WEST SUSSEX COUNTY COUNCIL CONSULTATION

TO:	Arun District Council FAO: Katie Sharp
FROM:	WSCC - Highway Authority
DATE:	23rd September 2022
LOCATION:	Land north of Toddington Lane (adjacent to Lyminster Bypass) Hampton Park Littlehampton BN17 7PP
SUBJECT:	LU/417/21/OUT Outline application with some matters reserved (except access) for the erection of up to 71 No dwellings. Further information received in Katie Sharp's email of 26th August 2022.
DATE OF SITE VISIT:	16 th September 2022 + desktop study
RECOMMENDATION:	No Highway Objection
S106 CONTRIBUTION TOTAL:	Please see below

This is the third WSCC County Highways (CHA) response to the above outline planning application with some matters reserved (except access) for the erection of up to 71 dwellings. Comments below respond to additional information received from the applicant's transport consultant between 20th September and 23rd September 2022. Comments should be read alongside previous WSCC Highways responses dated 16th February 2022 and 8th September 2022.

JOB TITLE		CLIENT	
Toddington Lane, Littlehampton		T & L Crawley No.2 LLP	
DRAWING TITLE			
Site Access Visibility Splays			
SCALE	DRAWN BY	DATE	DRAWING No
1/2500A3	BP	Oct21	23104-01
REVISION

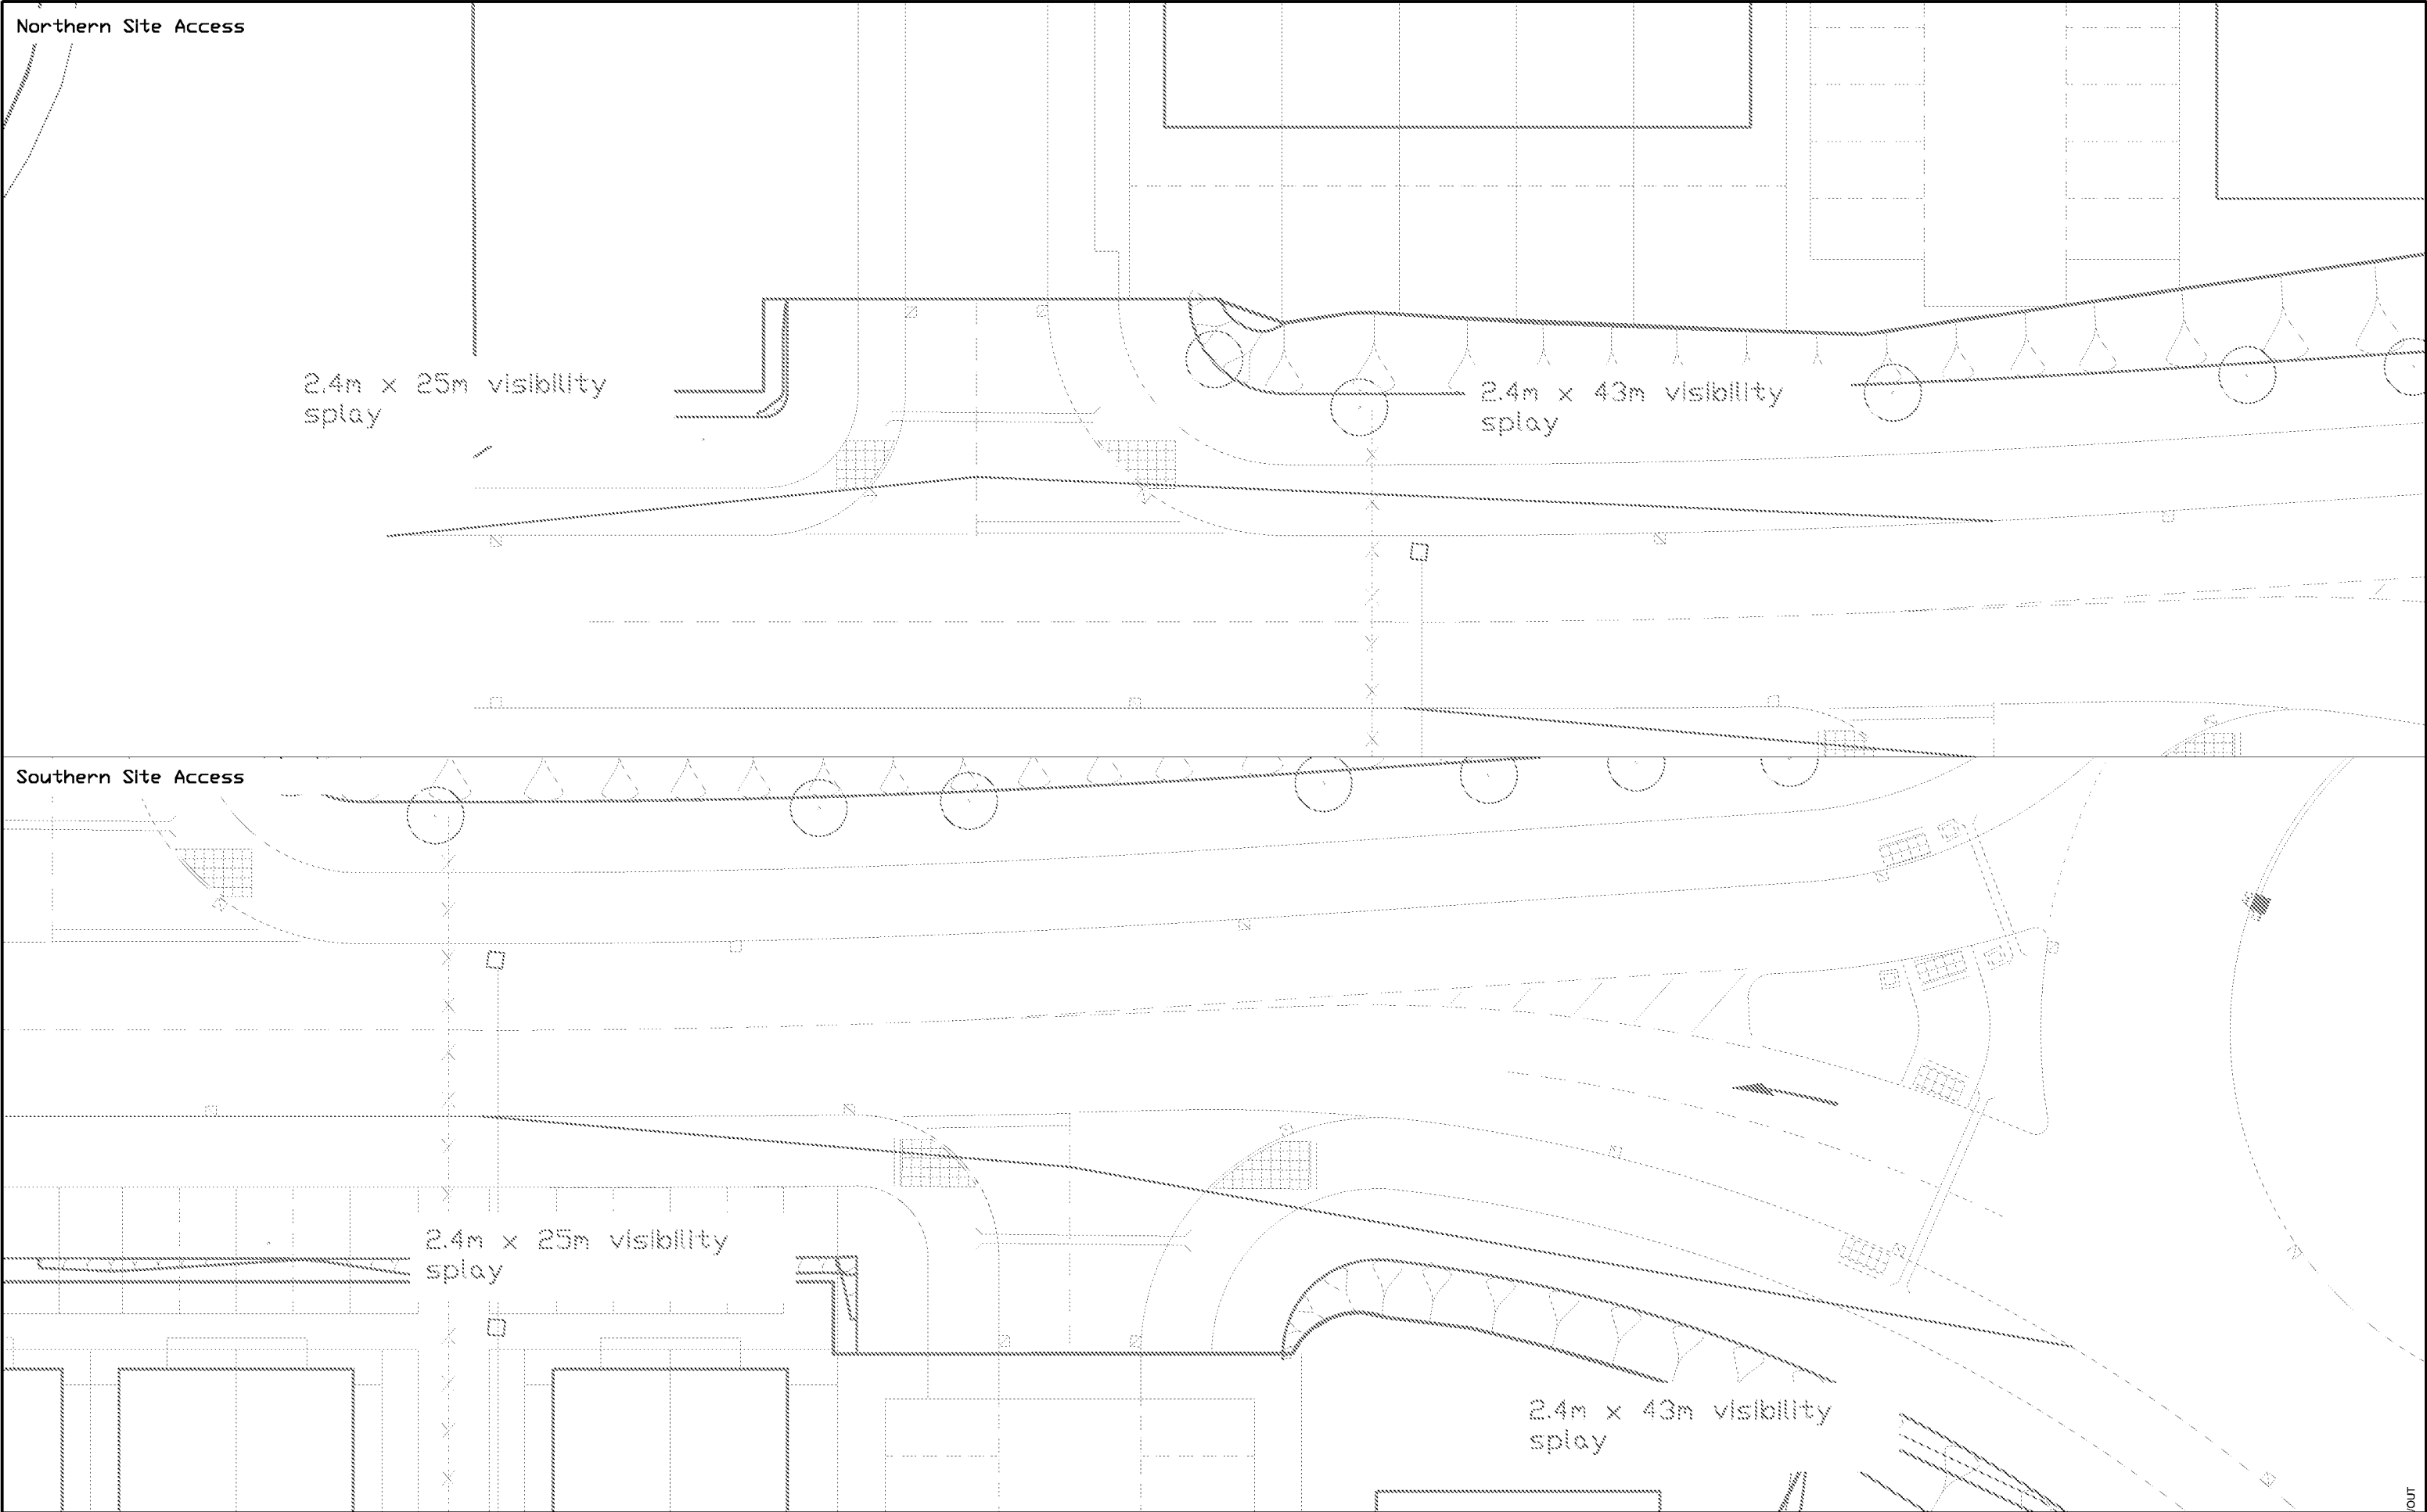
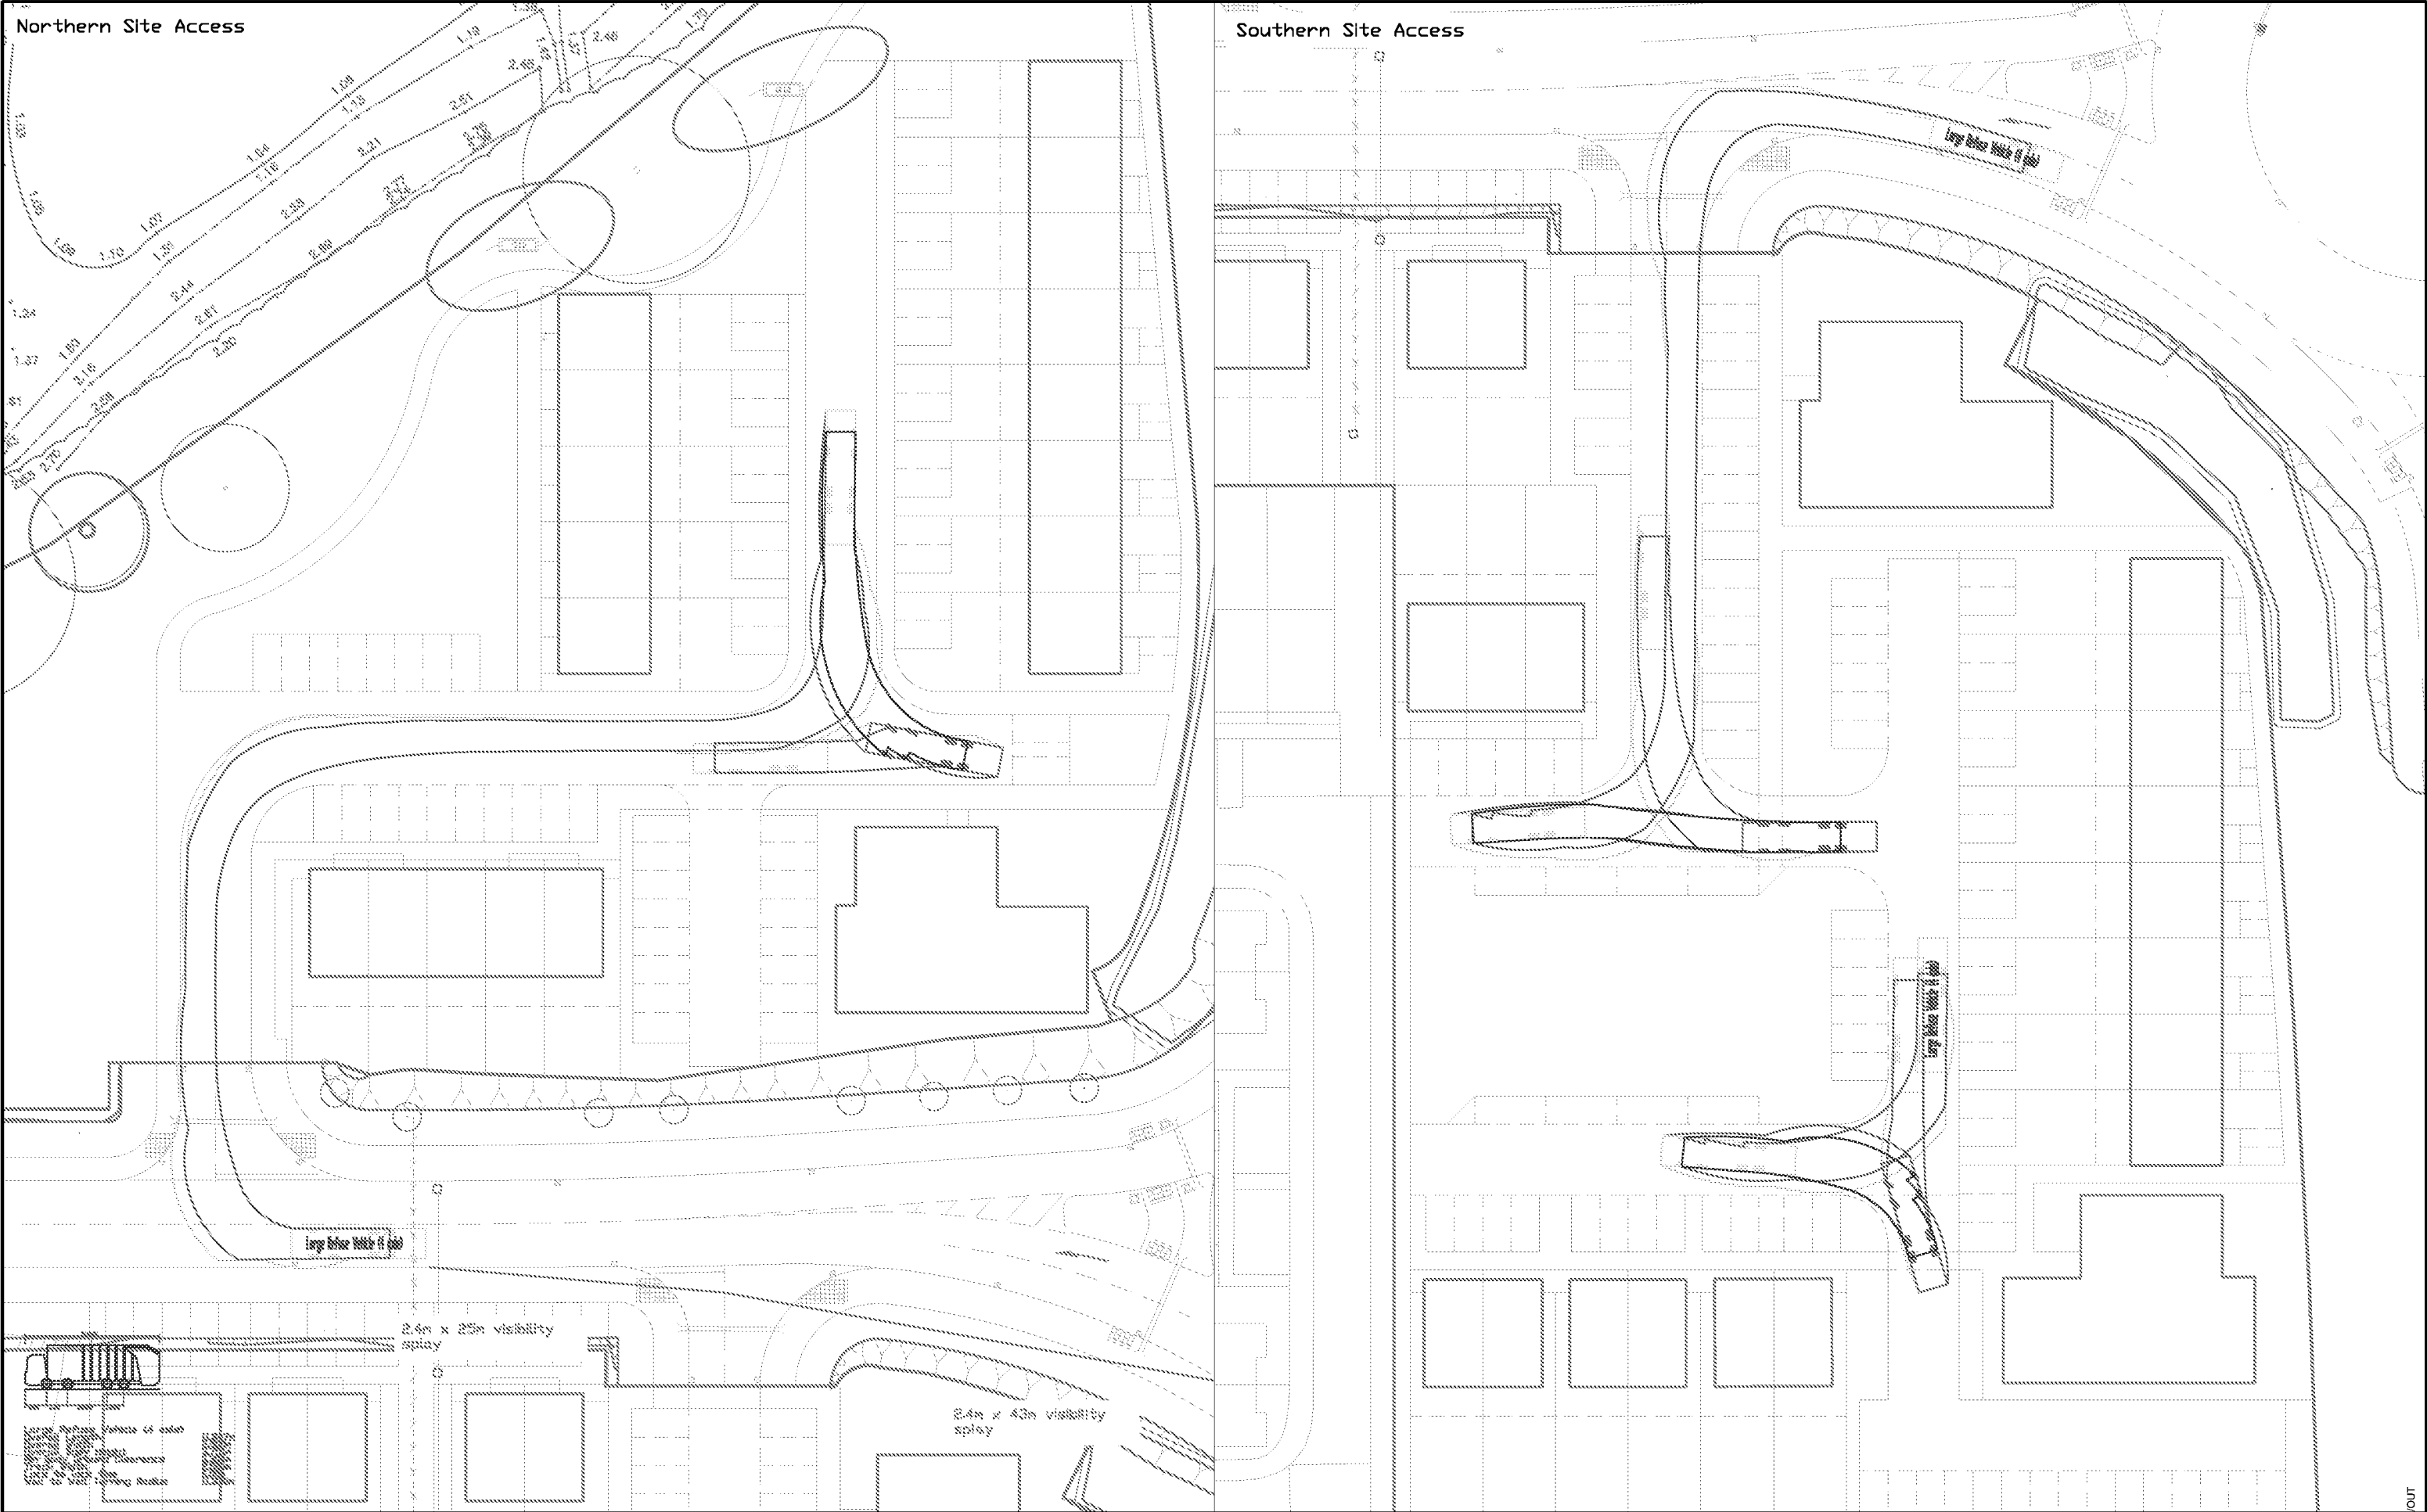
Additionally, the final design of the tie-in points for the shared foot and cycleways where they enter and leave the development parcels, will need to be amended and agreed at the detailed design stage. In particular, road markings for the tie-ins should either be located wholly on public highway or wholly on private land (access/roadway) for maintenance reasons.

The development shall not be commenced until such time as the vehicular access serving the development has been constructed generally in accordance with the details shown on Drawing's 23104-02 Revision 'A' (albeit with revisions to the interface points of the shared foot and cycle ways where they enter each development parcel - to be agreed with the Highway Authority prior to works commencing), or as otherwise may be agreed with the Highway Authority.
